From: Amanda Scholes on behalf of Planning.Responses
Sent: 12 July 2017 09:12
To: Planning Scanning
Subject: FW: Planning Application BE/63/17/OUT - The Cottage, Shripney Road, Bognor Regis

We have taken a look over the Technical Note produced by Motion dated 27th June 2017.

Subject: Planning Application BE/63/17/OUT - The Cottage, Shripney Road, Bognor Regis

Visibility and Access Arrangements

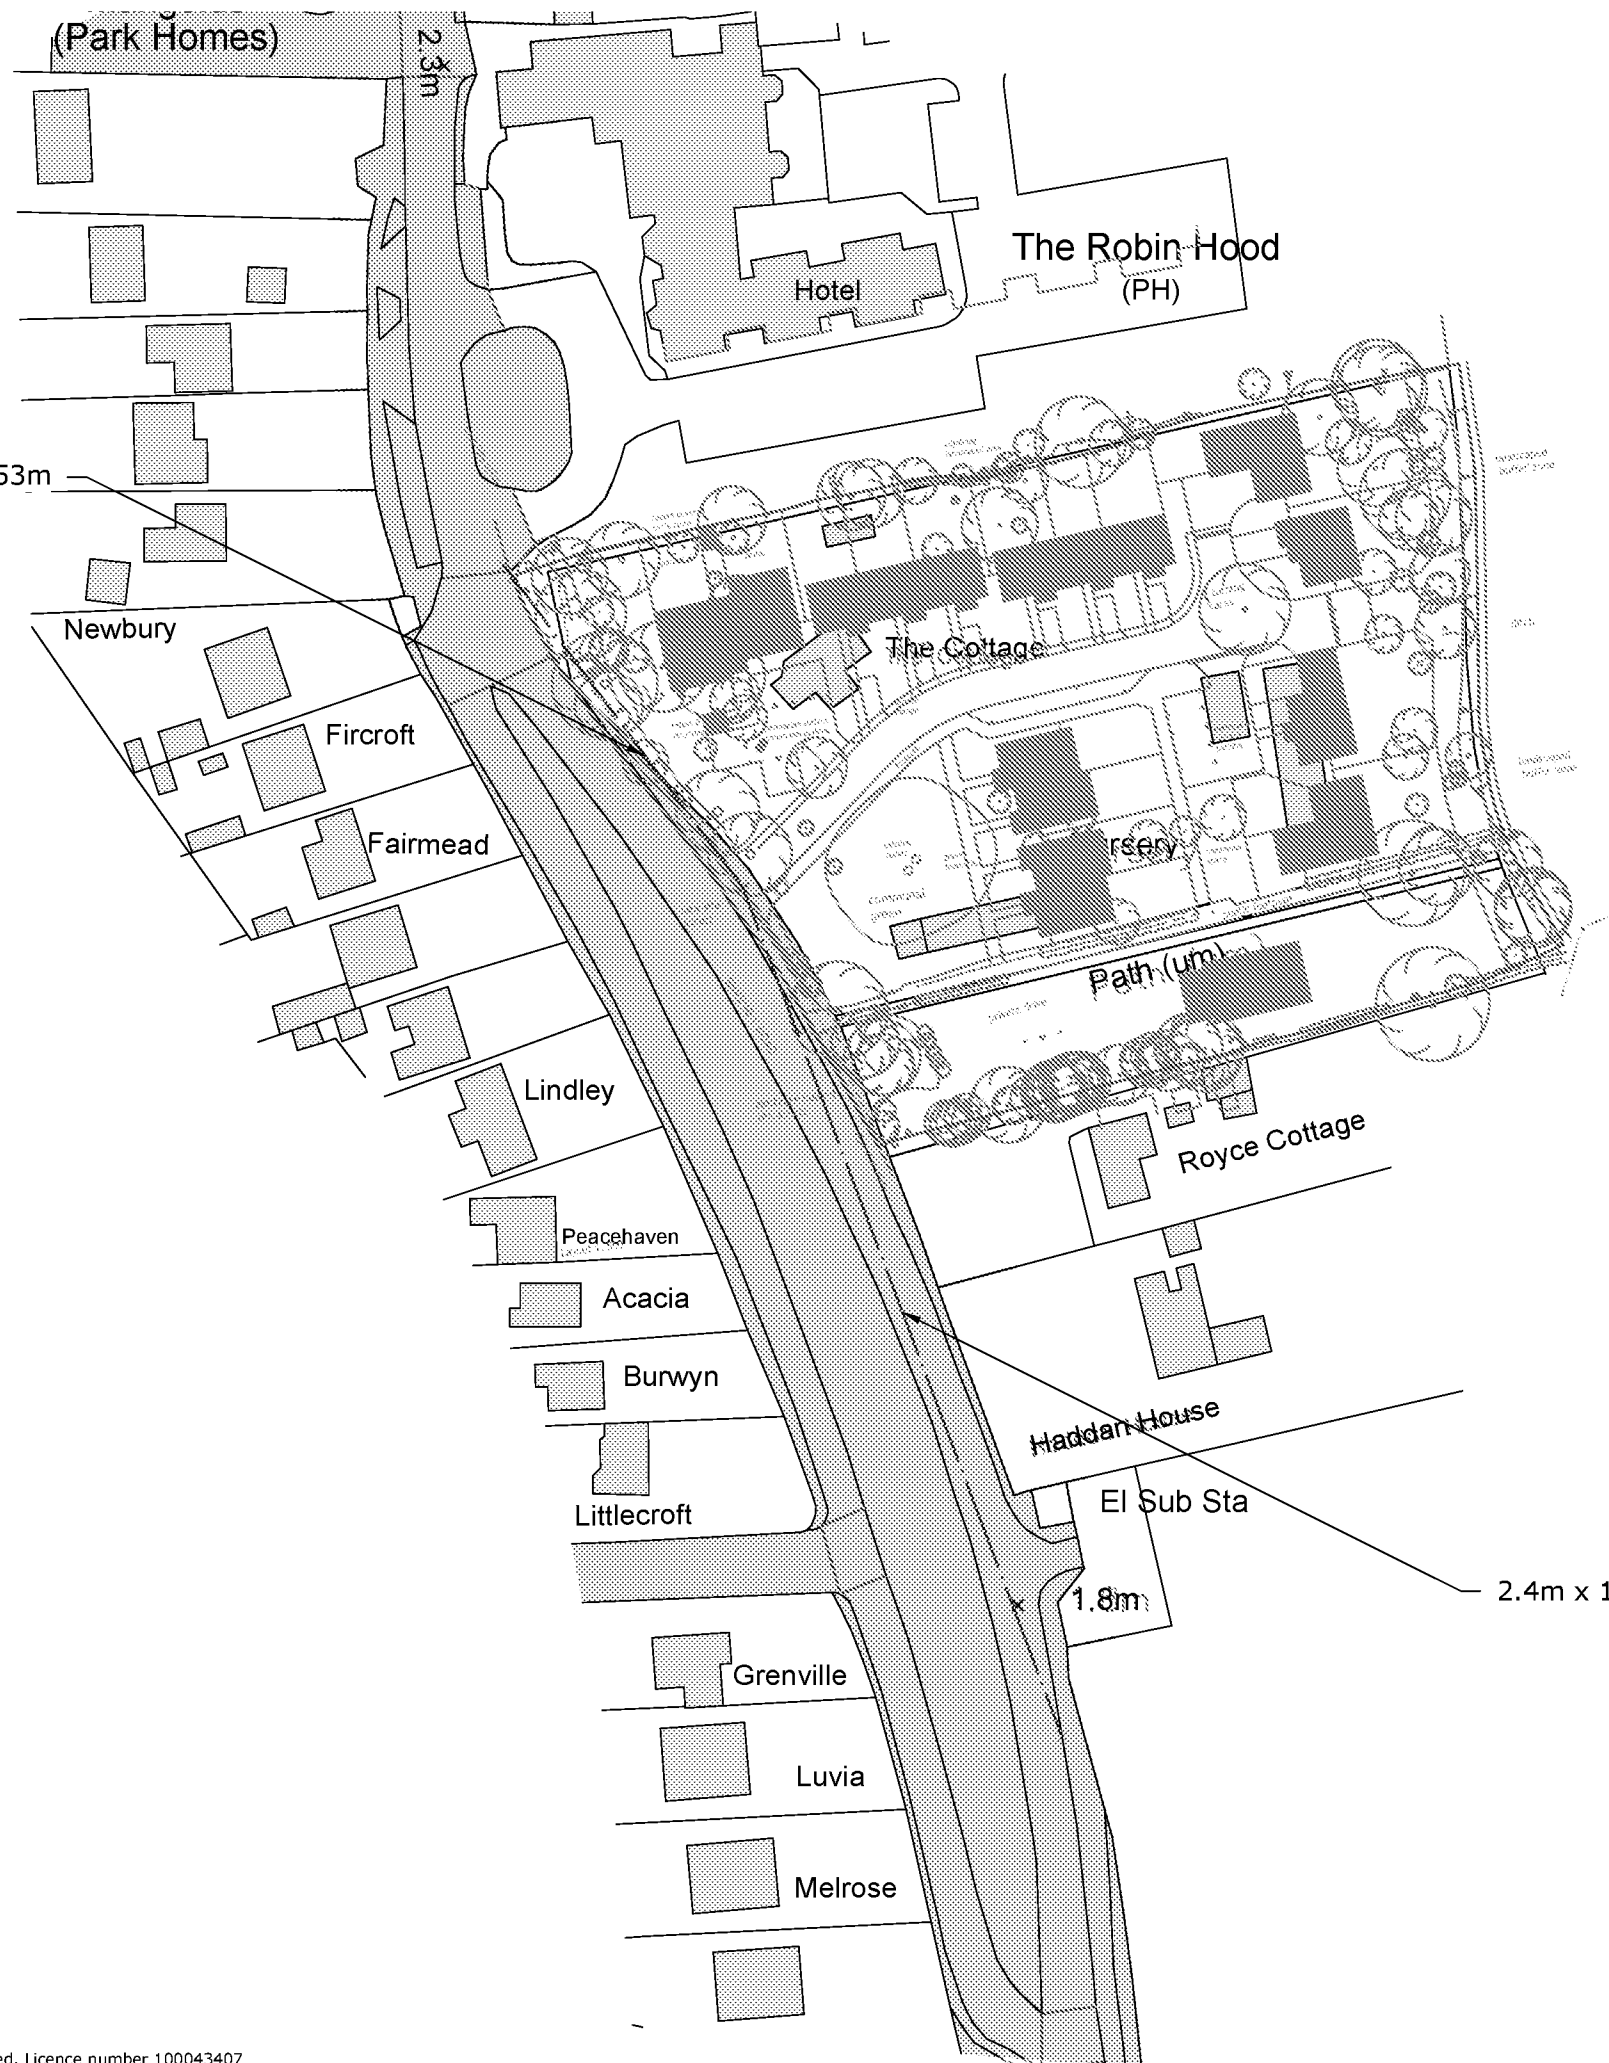
The visibility splays need to comply with DMRB standards for a 40 mph road. If a Departure from Standard was to be applied for this would have to be supported by a new ATC survey, not carried out in the holiday period. Two loops would be required, one to record speeds of traffic traveling from Bognor northbound. This needs to be placed as close to the 120m forward visibility line as possible and will highlight vehicle speeds of a vehicle traveling along at the point of where they would spot a vehicle waiting to turn right into the development or a vehicle exiting to the right from the development. The second loop needs to be placed at the point where a vehicle traveling southbound would be able to see the access/vehicle slowing to enter the access (so at the end of the shown achievable visibility splay of 71m on drawing 160818-07).
